WEST SUSSEX COUNTY COUNCIL CONSULTATION

TO:	Arun District Council FAO: Mrs A Gardner
FROM:	Highways, WSCC
DATE:	31/08/2018
LOCATION:	Crossbush Farm Shop, Lyminster Road, Lyminster, West Sussex, BN17 7QN
SUBJECT:	LY/15/18/DOC Approval of details reserved by condition imposed under LY/28/17/PL relating to conditions 5- equipment to control odour/fumes, 9-secured & covered cycle parking & 11- closing of Calceto Lane for egress of vehicles.
DATE OF SITE VISIT:	n/a
RECOMMENDATION:	☒ Advice ☐ Objection ☐ Modification ☐ No Objection ☐ More Information ☐ Refusal
S106 CONTRIBUTION TOTAL:	n/a

"Conical shaped cylinder housing which, along with the flange seal, are able to drastically reduce the entry of detritus up to 80 % when the cylinder is up."

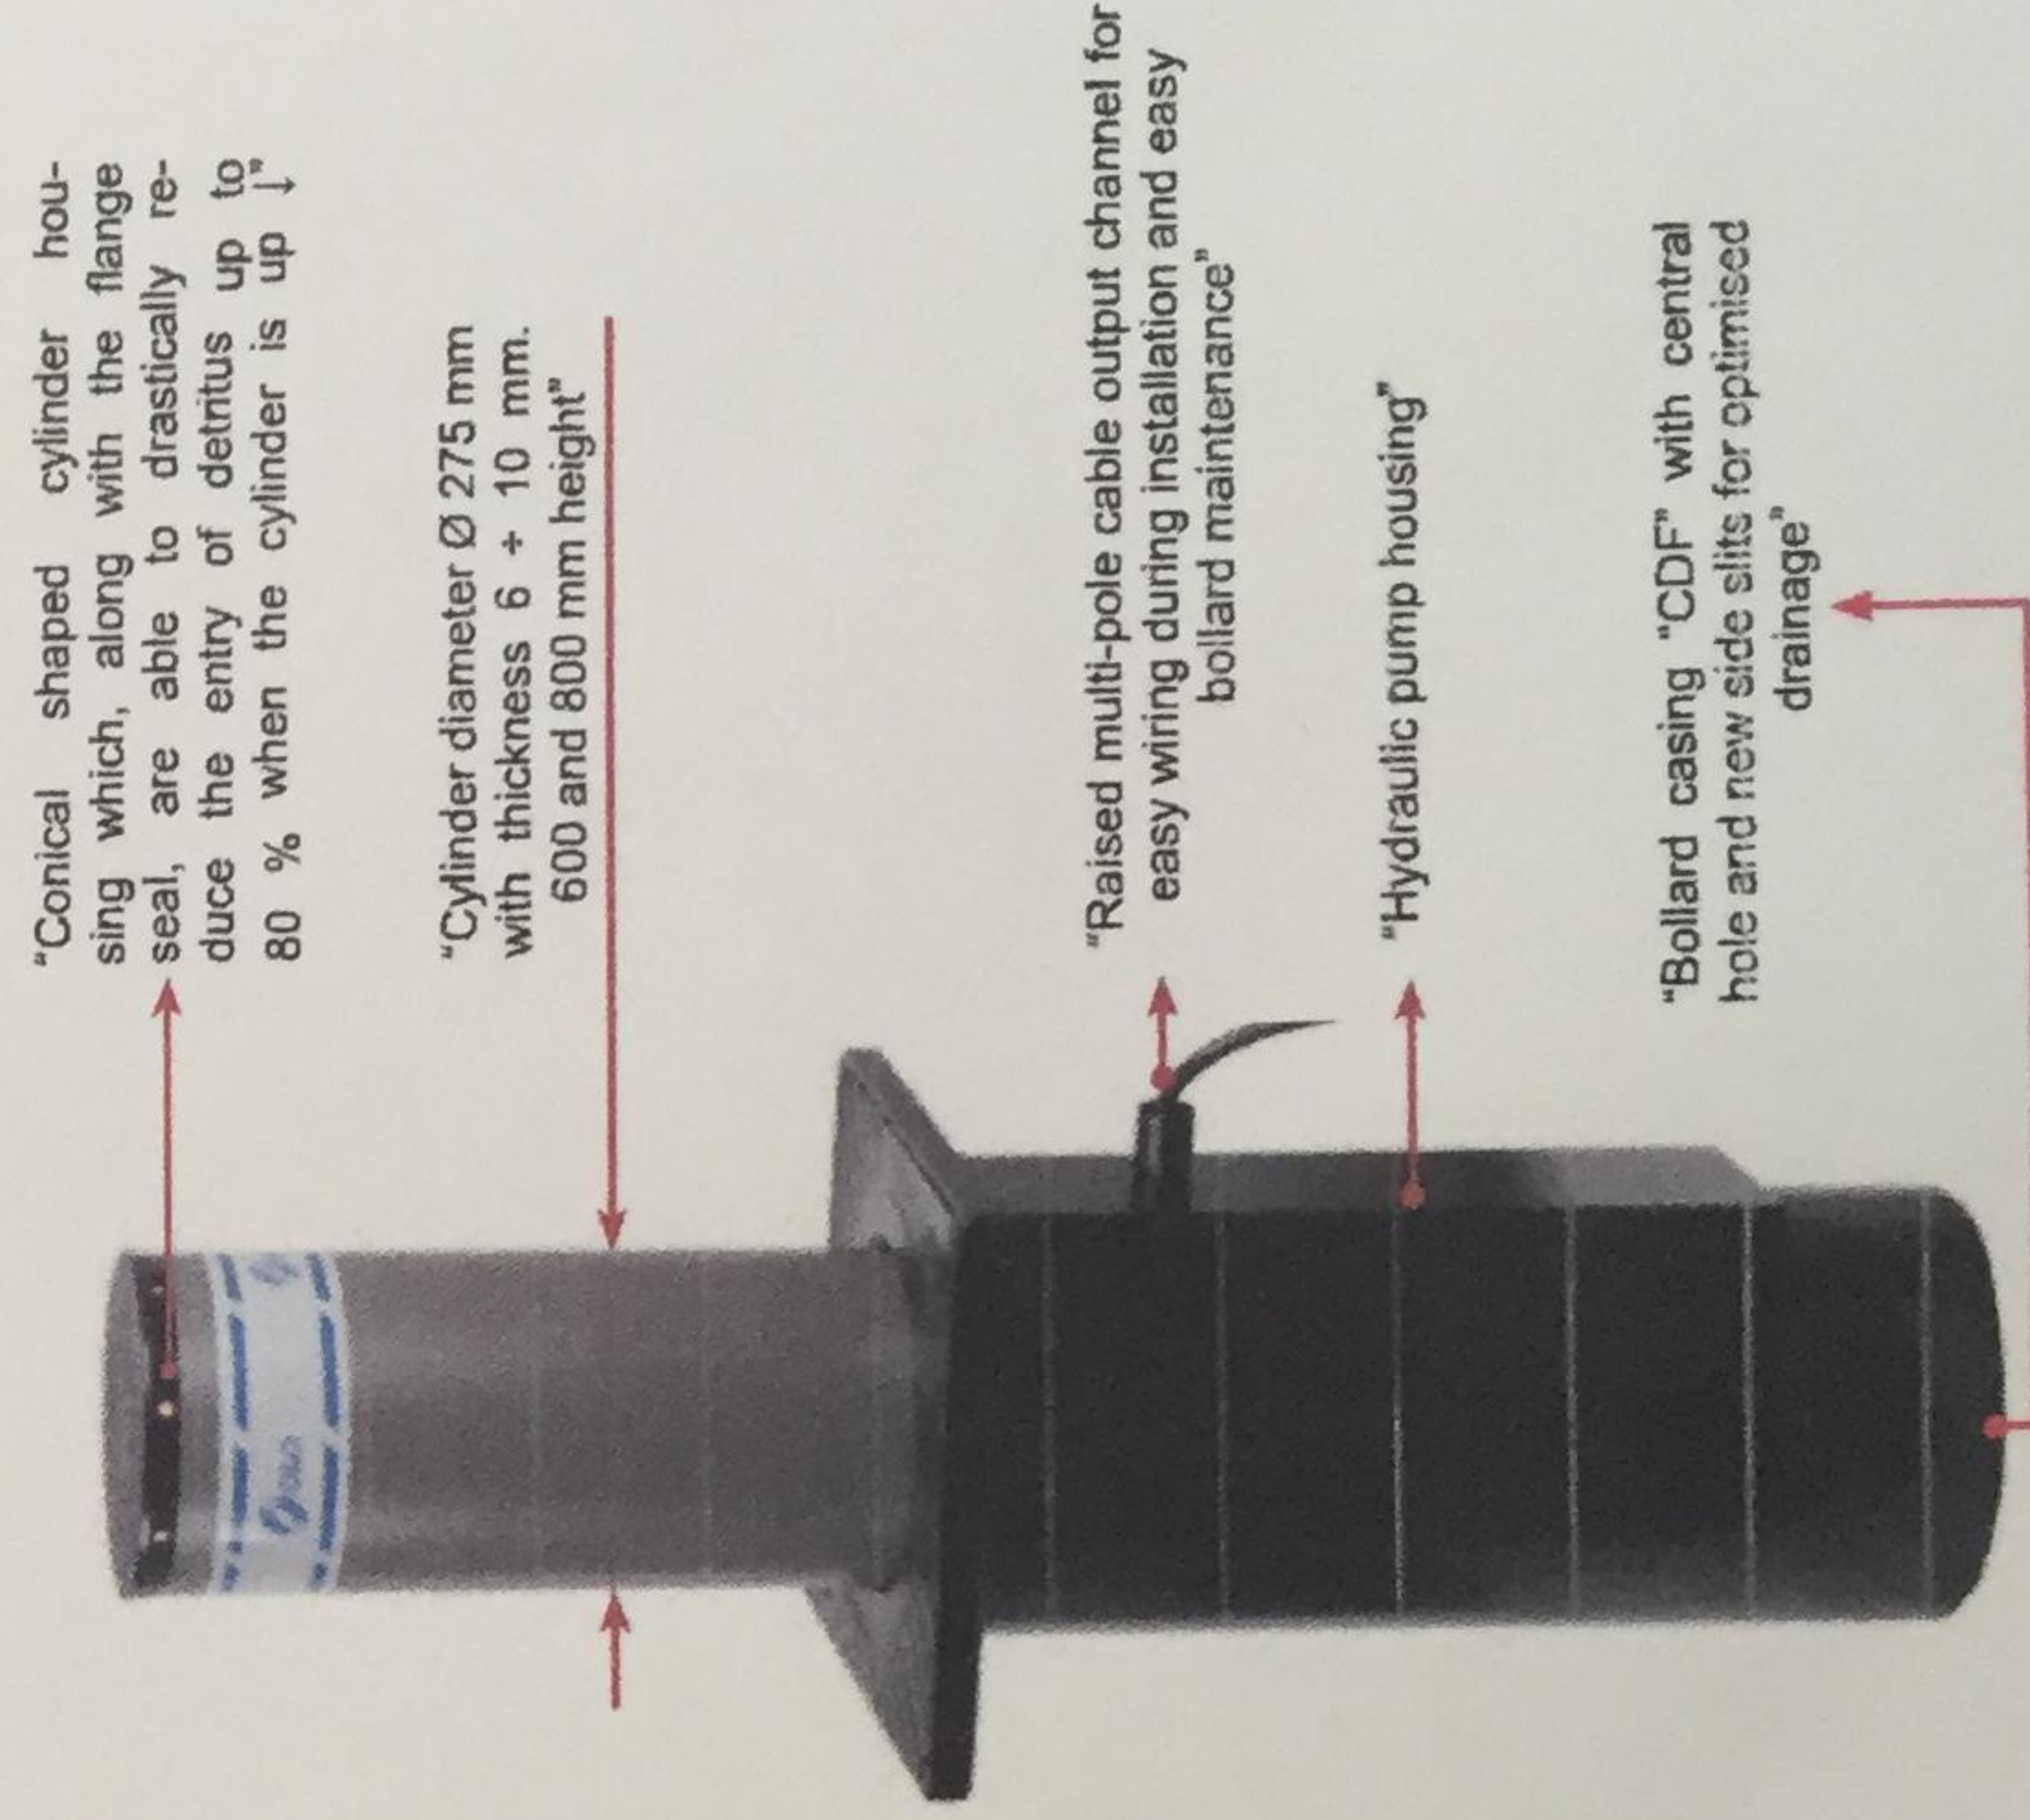
The applicant has submitted documentation detailing a raising bollard system that will be implemented to ensure ingress via Calceto Lane is achievable while restricting egress movements onto Lyminster Road.

I have consulted with WSCC Public Rights of Way and they are satisfied with the proposed.

The plans and details provided pertaining to this condition would be considered acceptable. If the Local Planning Authority are minded to grant approval I would ask an informative note is included requesting the applicant contact WSCC PROW [REDACTED] [REDACTED] after installation of the bollard.

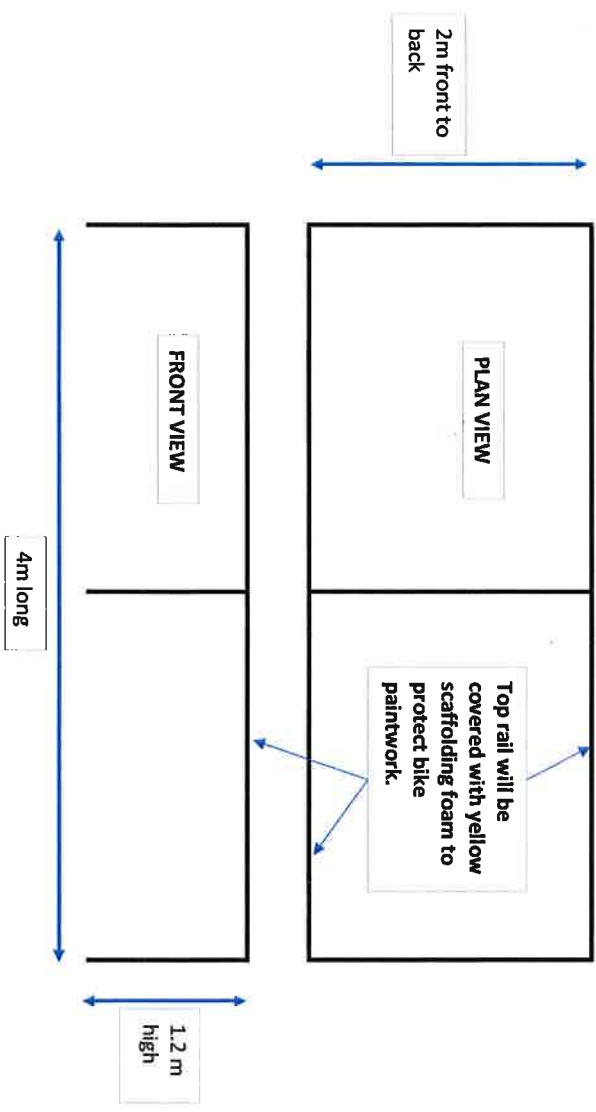
The applicant has submitted a plan detailing a covered cycle parking provision which can accommodate up to 24 cycles.

The plans and details provided pertaining to this condition would be considered acceptable.
